**Stephen O'Donoghue - FW: Cobbora Coal - revised PPR**

**From:** Phil Towler <ptowler@emgamm.com>  
**To:** Stephen O'Donoghue <Stephen.O'Donoghue@planning.nsw.gov.au>  
**Date:** Monday, 9 September 2013 11:45  
**Subject:** FW: Cobbora Coal - revised PPR

**Cobbora Coal Project (MP 10\_0001)  
Revised Preferred Project Report (PPR)**

Figure 5.7 Predicted groundwater levels 20 years after end of mining

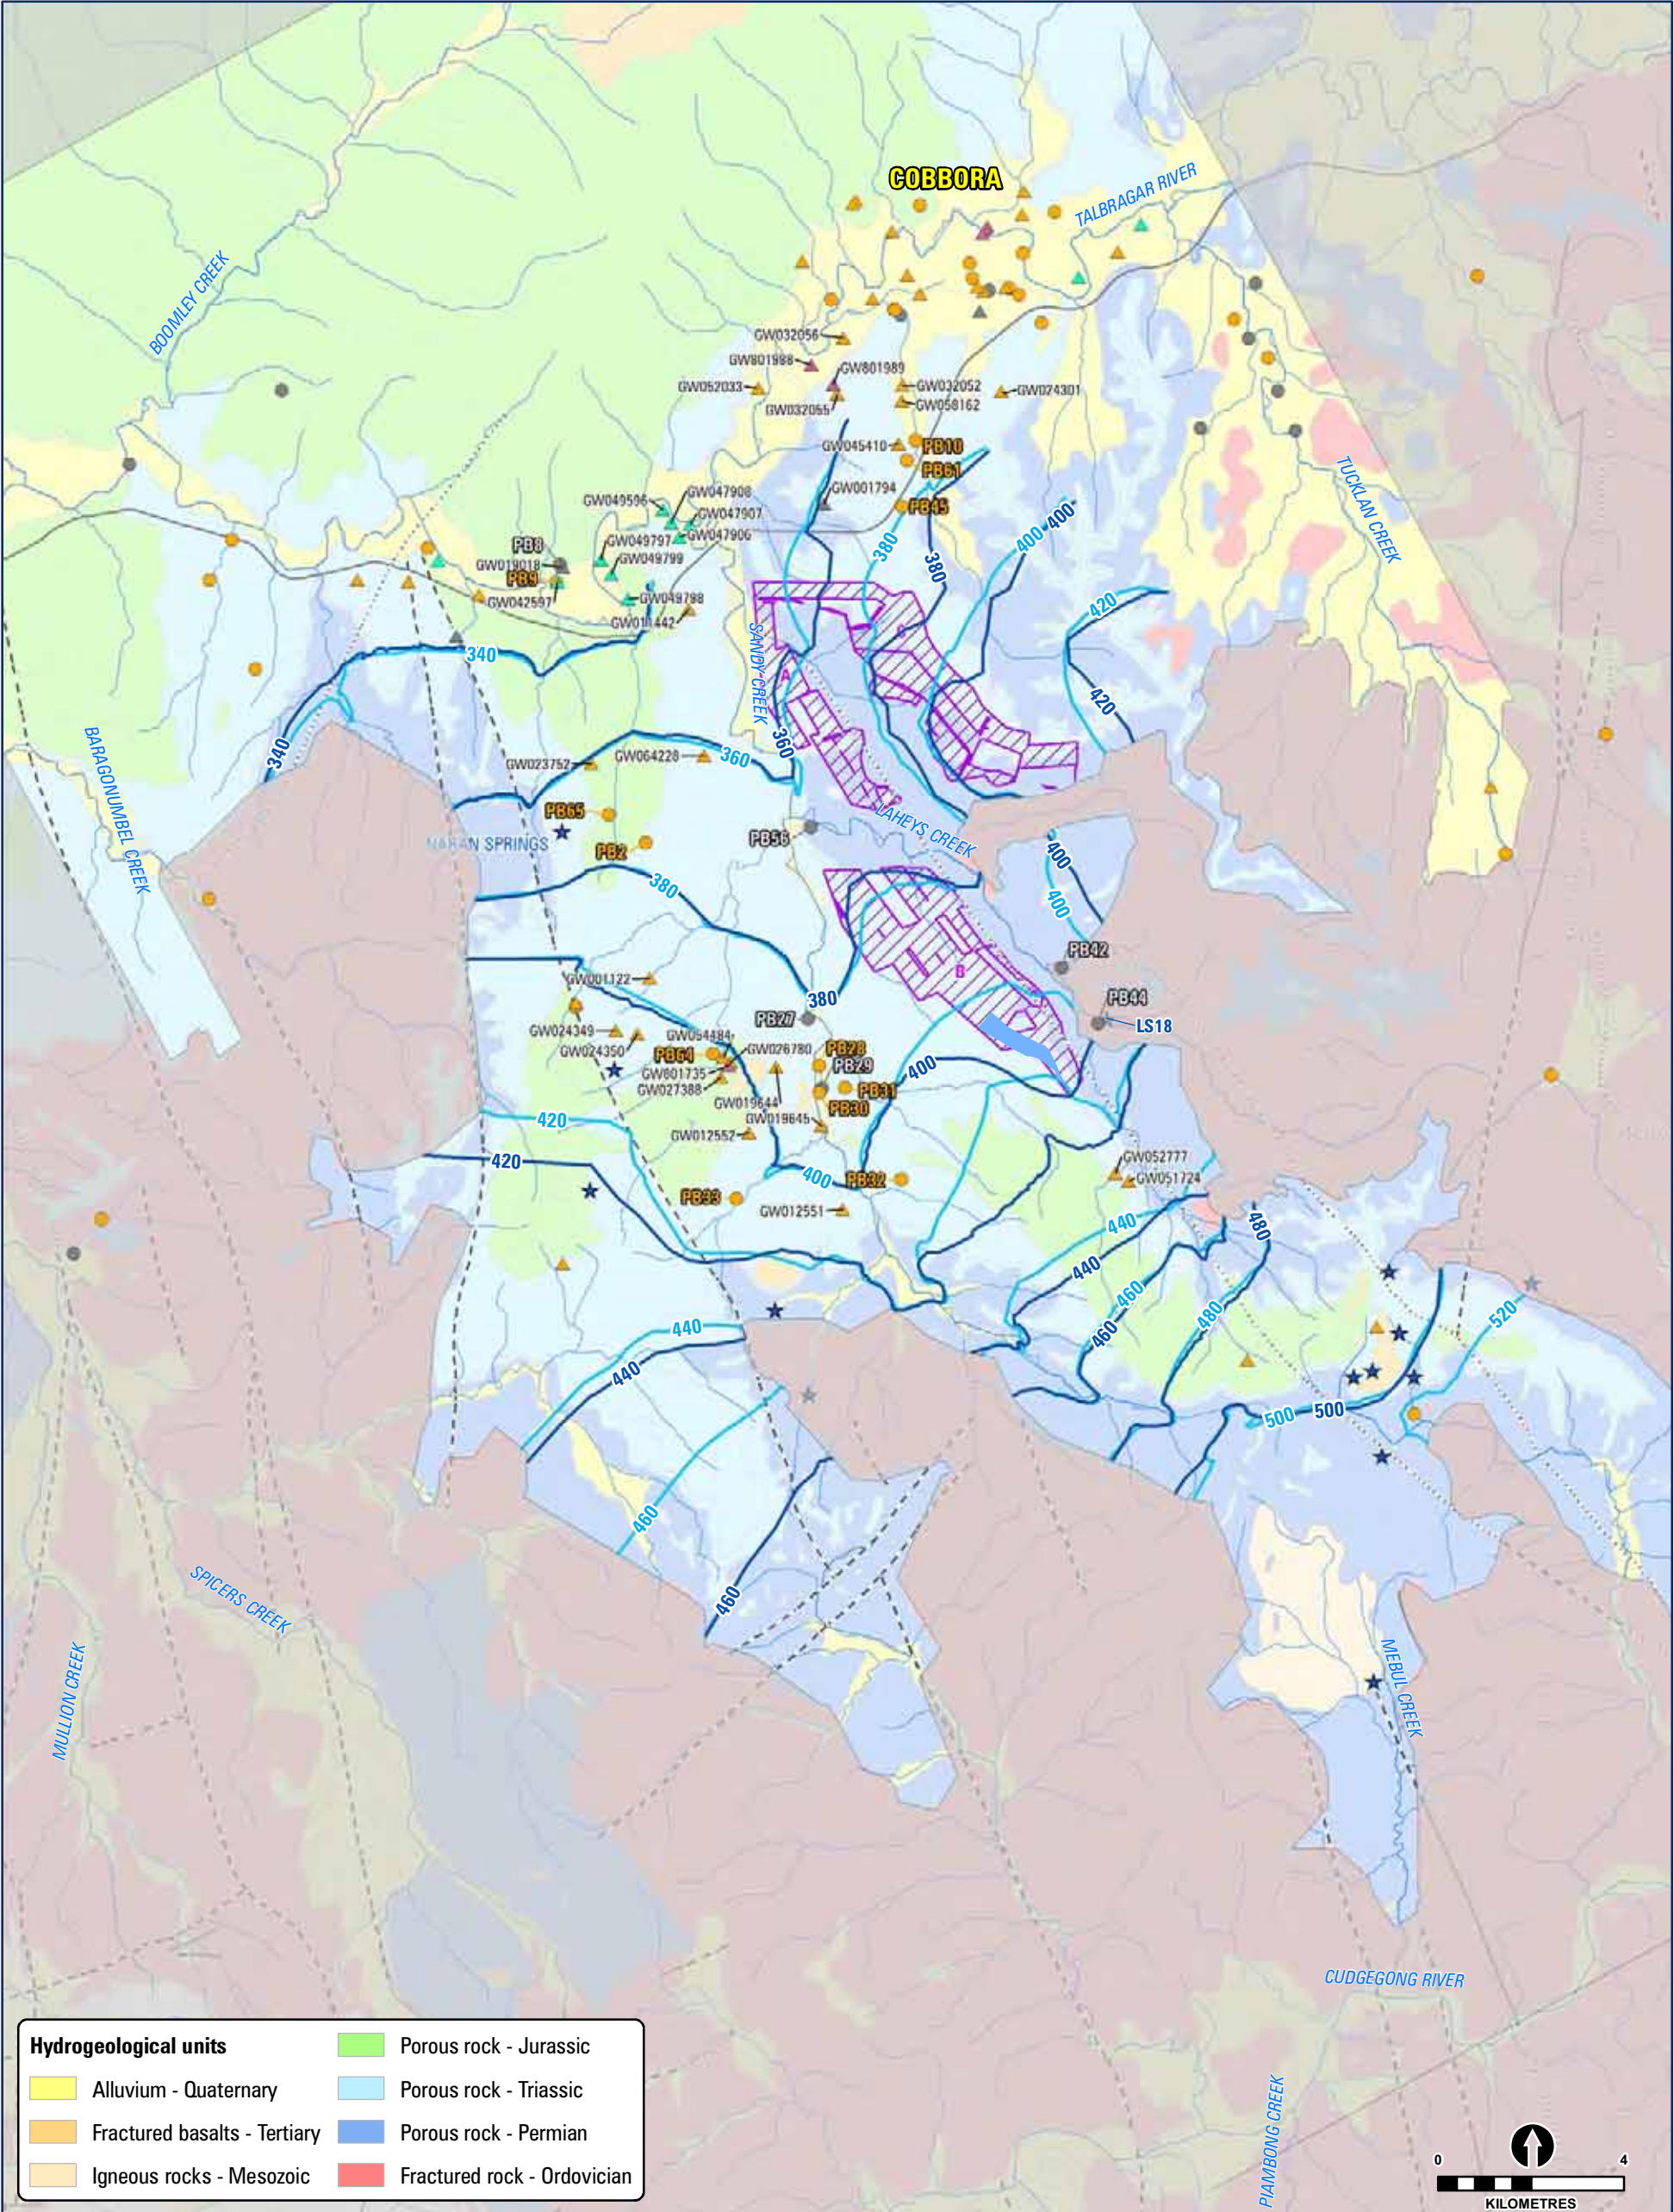
- Other changes in the revised PPR include reconfiguration of the final saline void lake dimensions and surrounding landform. The worst case scenario final water level is similar to the previous design. The reduced freeboard (to 6 metres) from this revised design still holds considerable storage before overtopping. The final void in the southern extent of mining area B remains a regional groundwater sink.

- A revised cross-sectional diagram of the final landform across mining area B is requested to illustrate the regional surface and groundwater features and revised final void geometry.

Agree.

The regional surface and groundwater features will not be changed significantly. A cross-section of mining area B is presented in Figure 3.15 of the PAC Responses Report.
